CITY OF ALBUQUERQUE

April 12, 2022

Re: Champion Xpress
2100 Central Ave. SW
Traffic Circulation Layout
Architect's Stamp XX-XX-XX (J13-D216)

Based upon the information provided in your submittal received 4-1-22, the above referenced plan cannot be approved for Building Permit until the following comments are addressed:

1 ARCHITECTURAL SITE

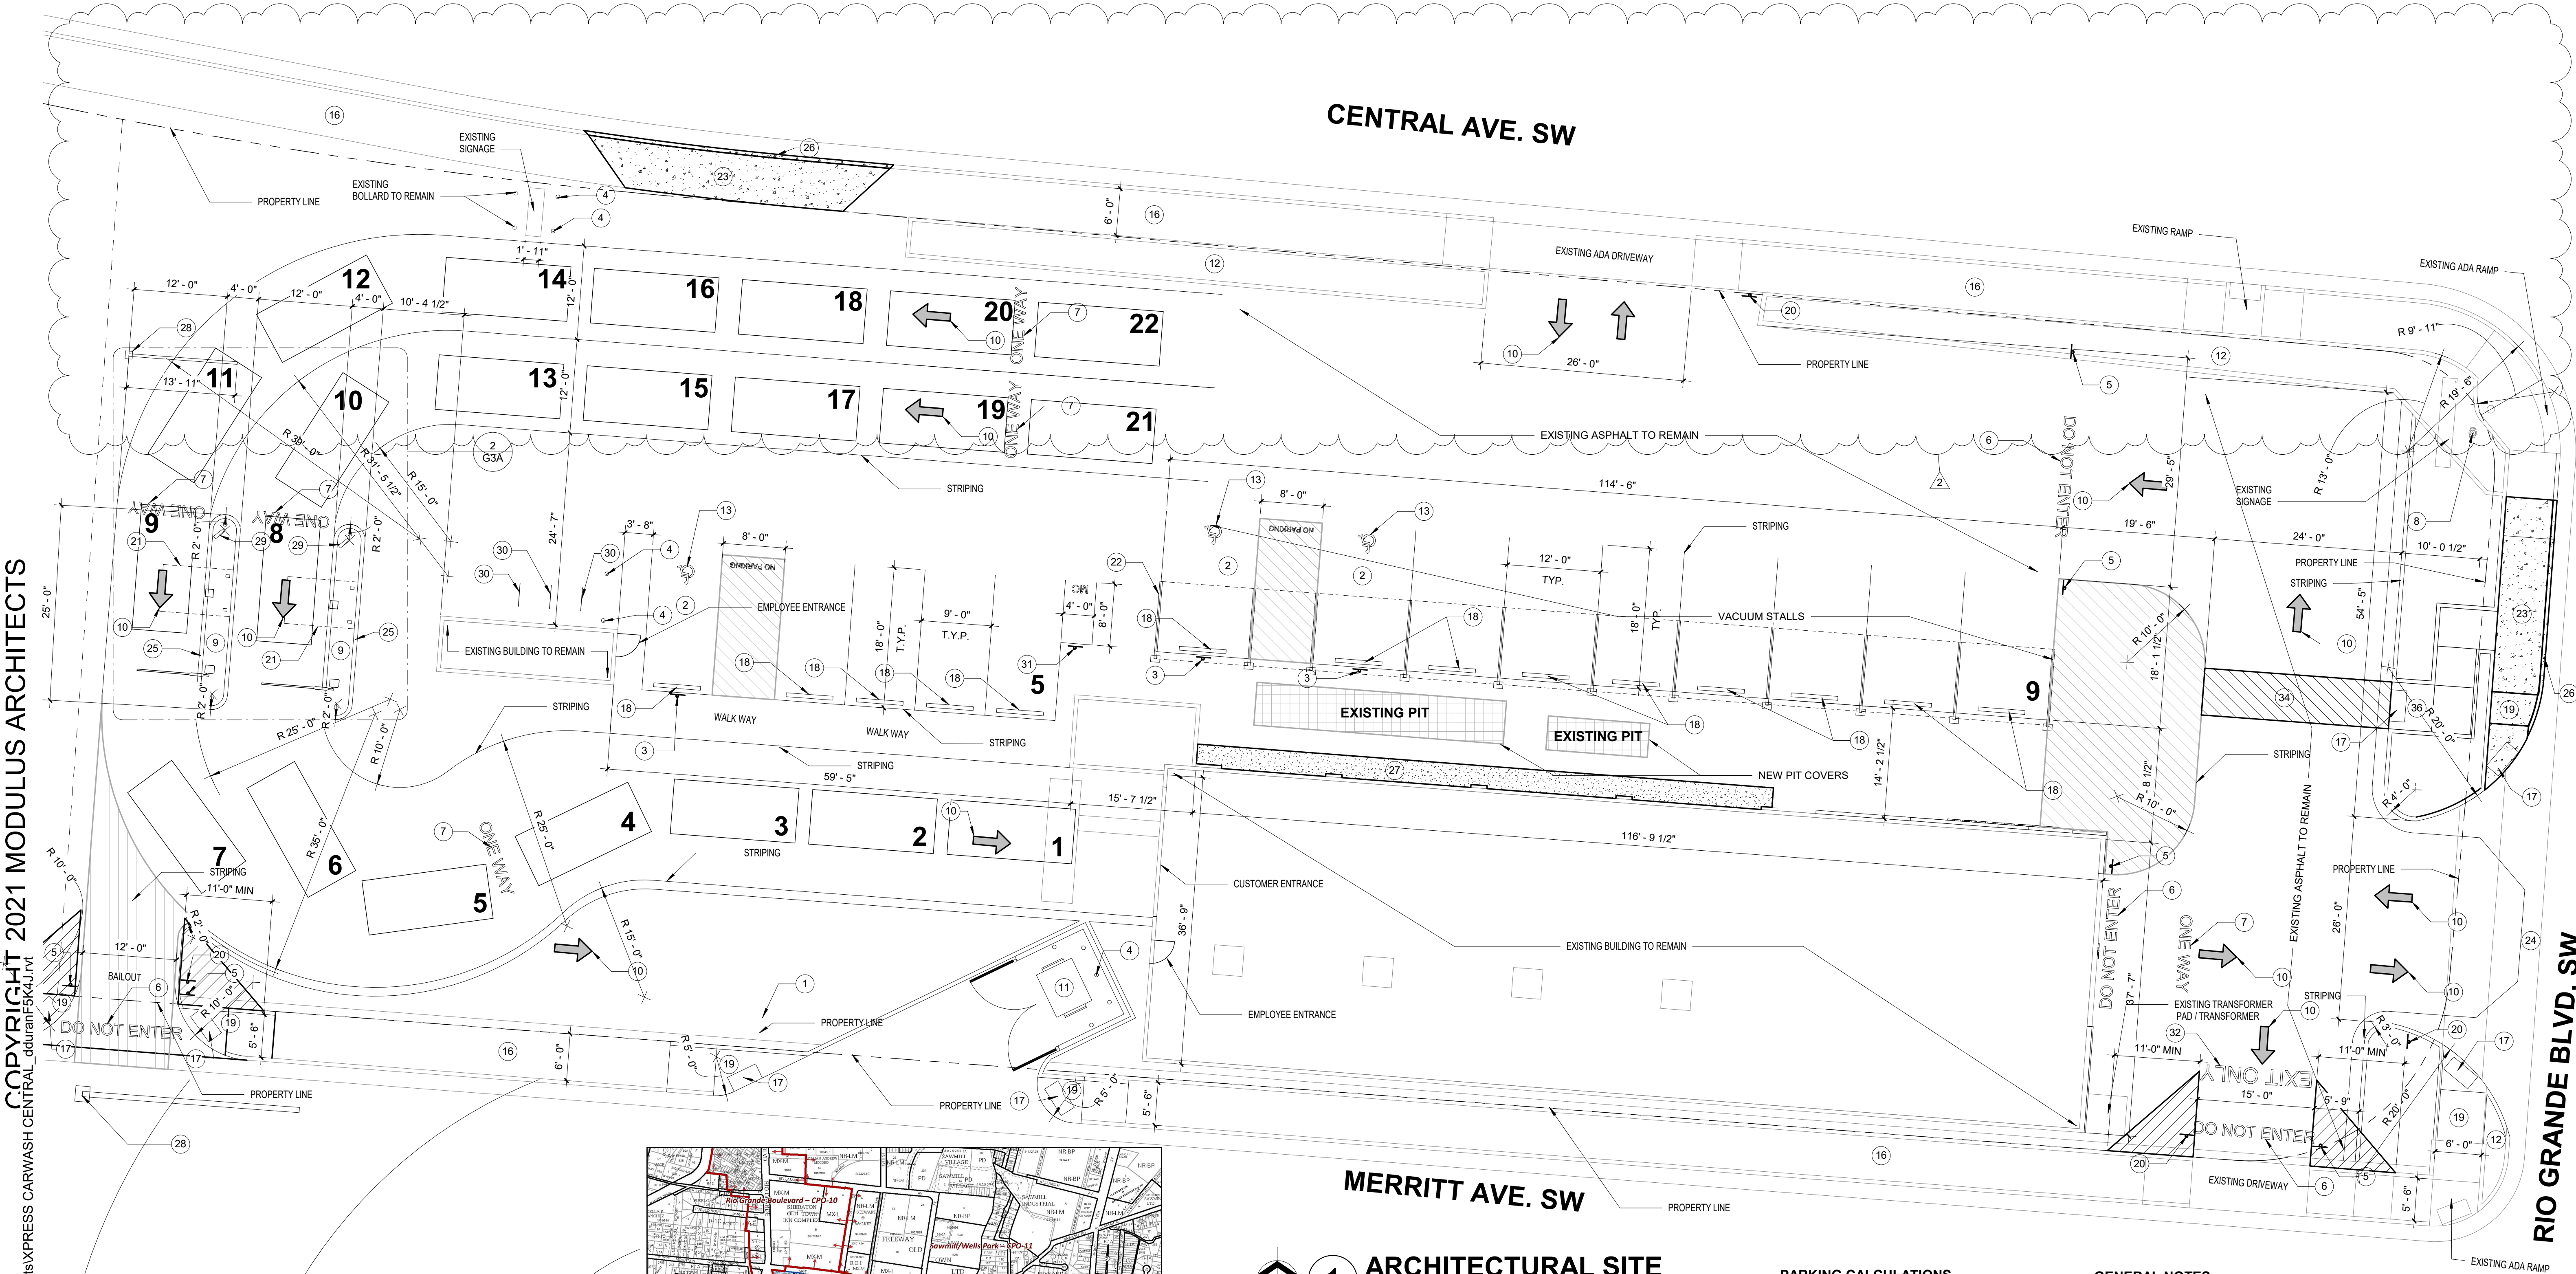
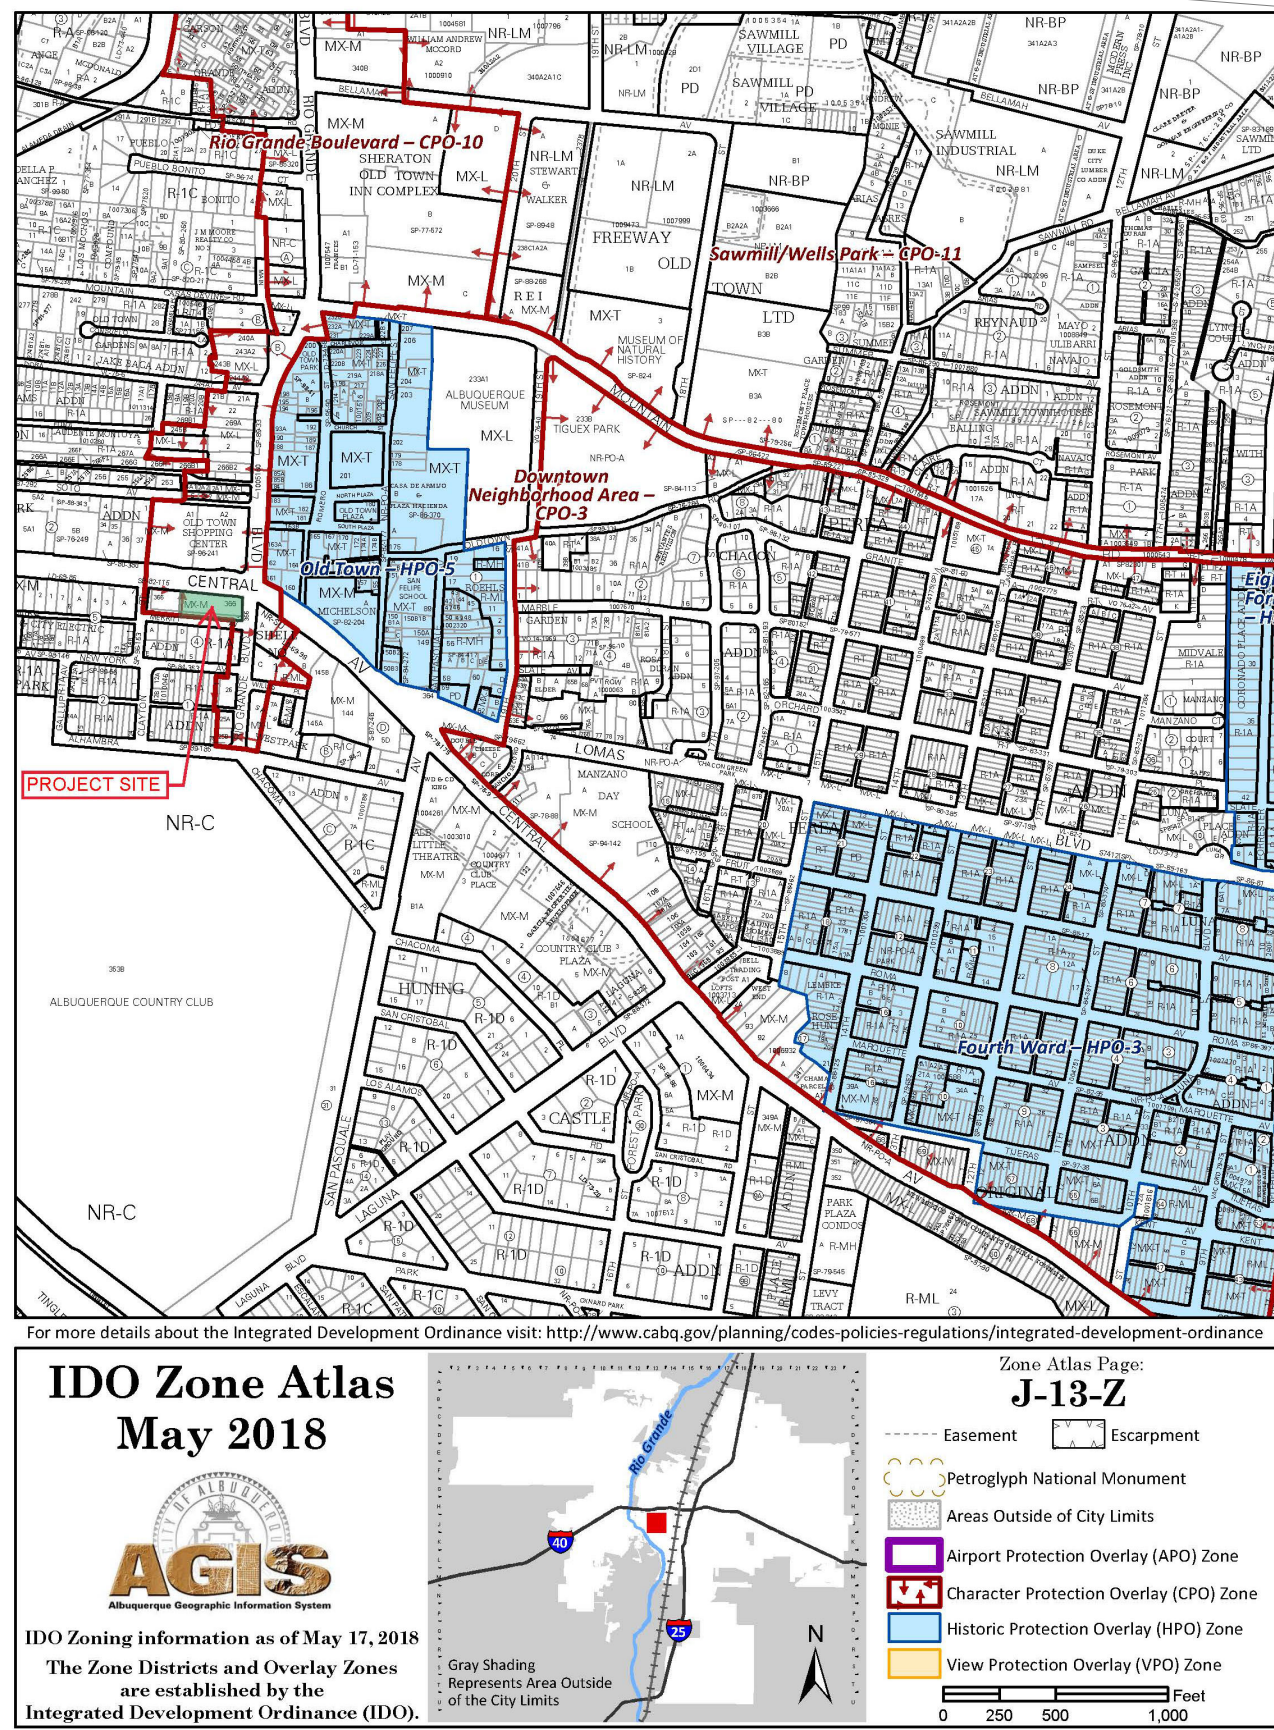
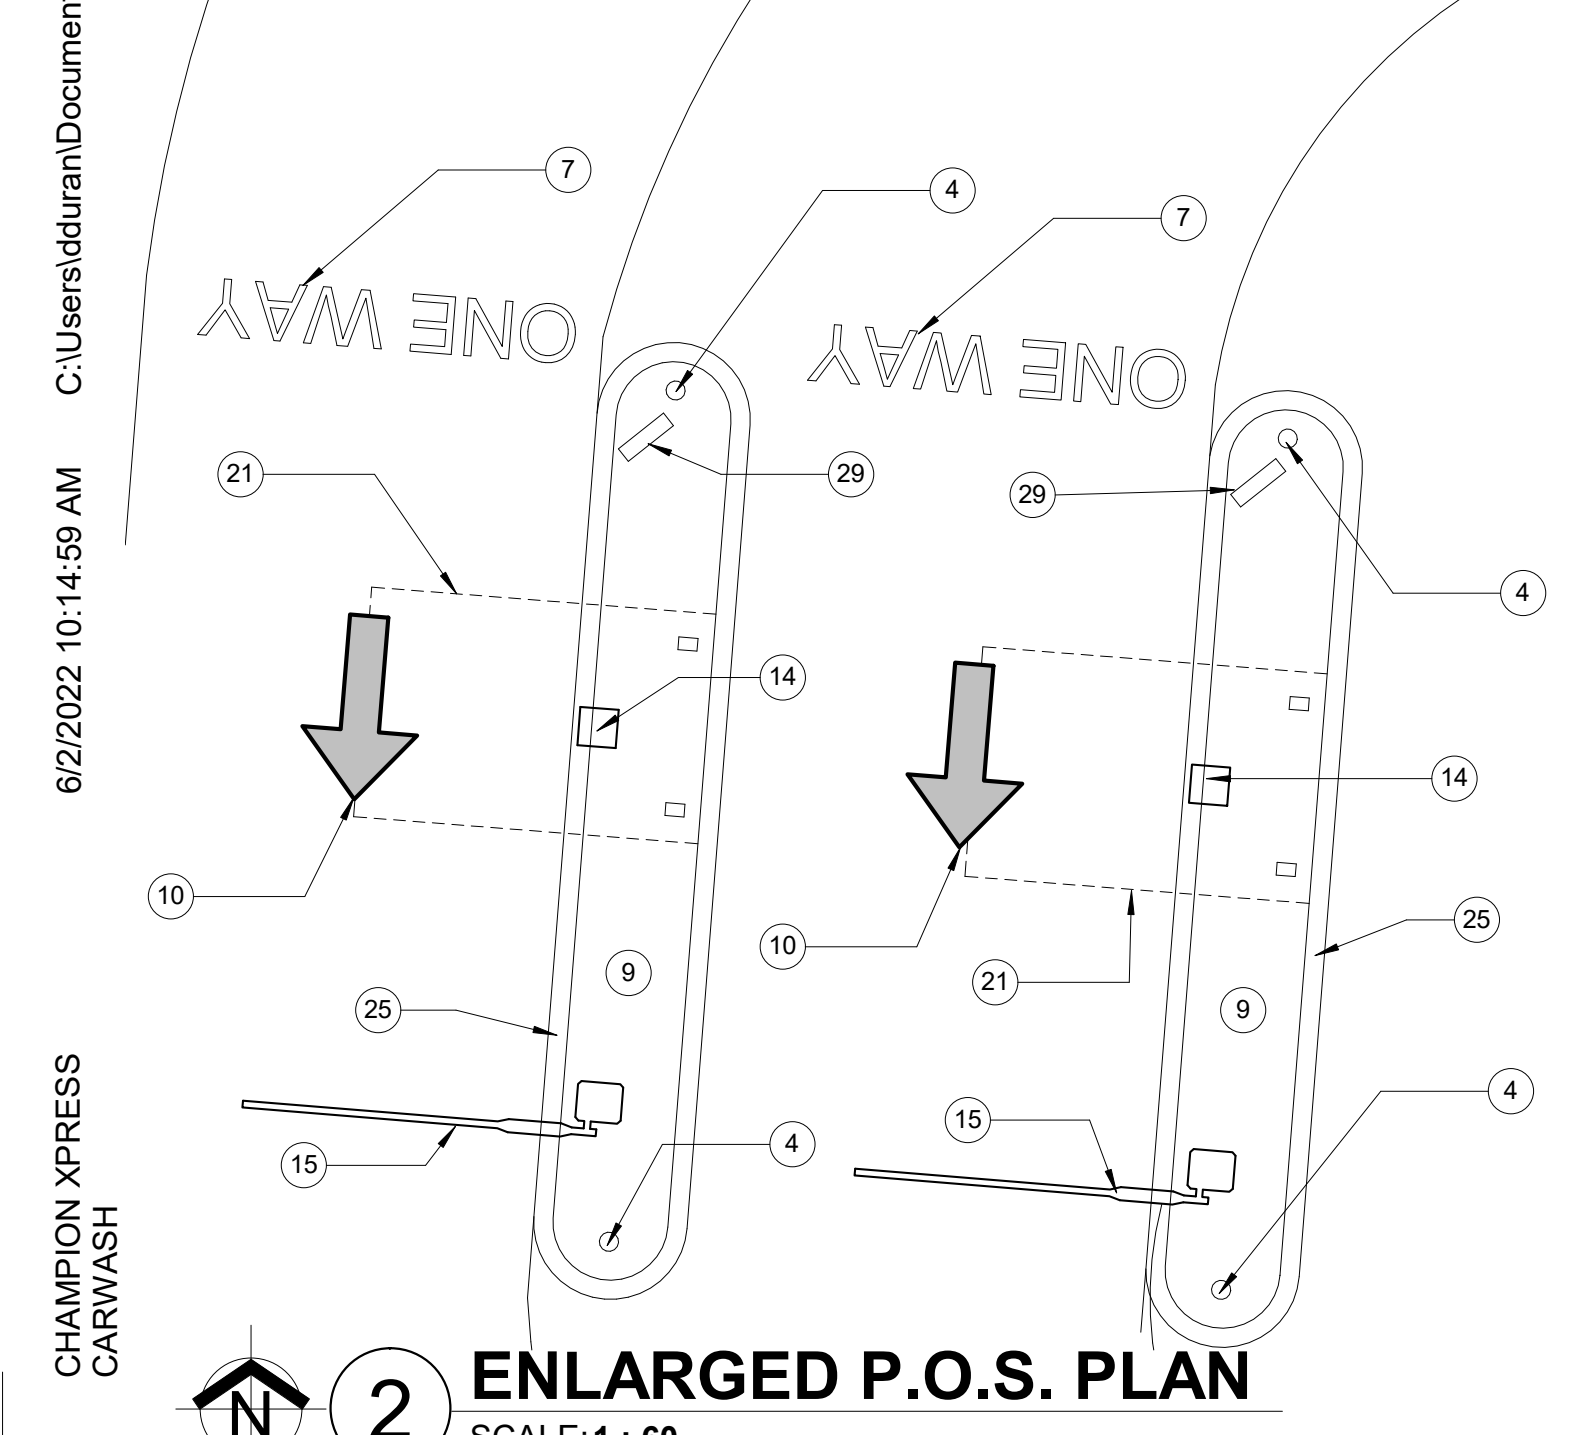
3. Key note 19: please verify what type of ramp you will use? The parallel, corner, or the perpendicular ramp?
4. What is the status of the 6' pedestrian path way from the public sidewalk to the building entrance? Is it flush all the way long? Please provide details.

5. What is the status of the 6' ADA path way form the ADA aisle to the building entrance? Please provide details.
6. Show the building entrance on the site plan.

7. Reference COA std dwg for the Driveway entrance off Central Ave. and provide the radius.
8. See attached for the new Bicycle Rack Requirements.
9. All sidewalks along streets should be placed at the property line.
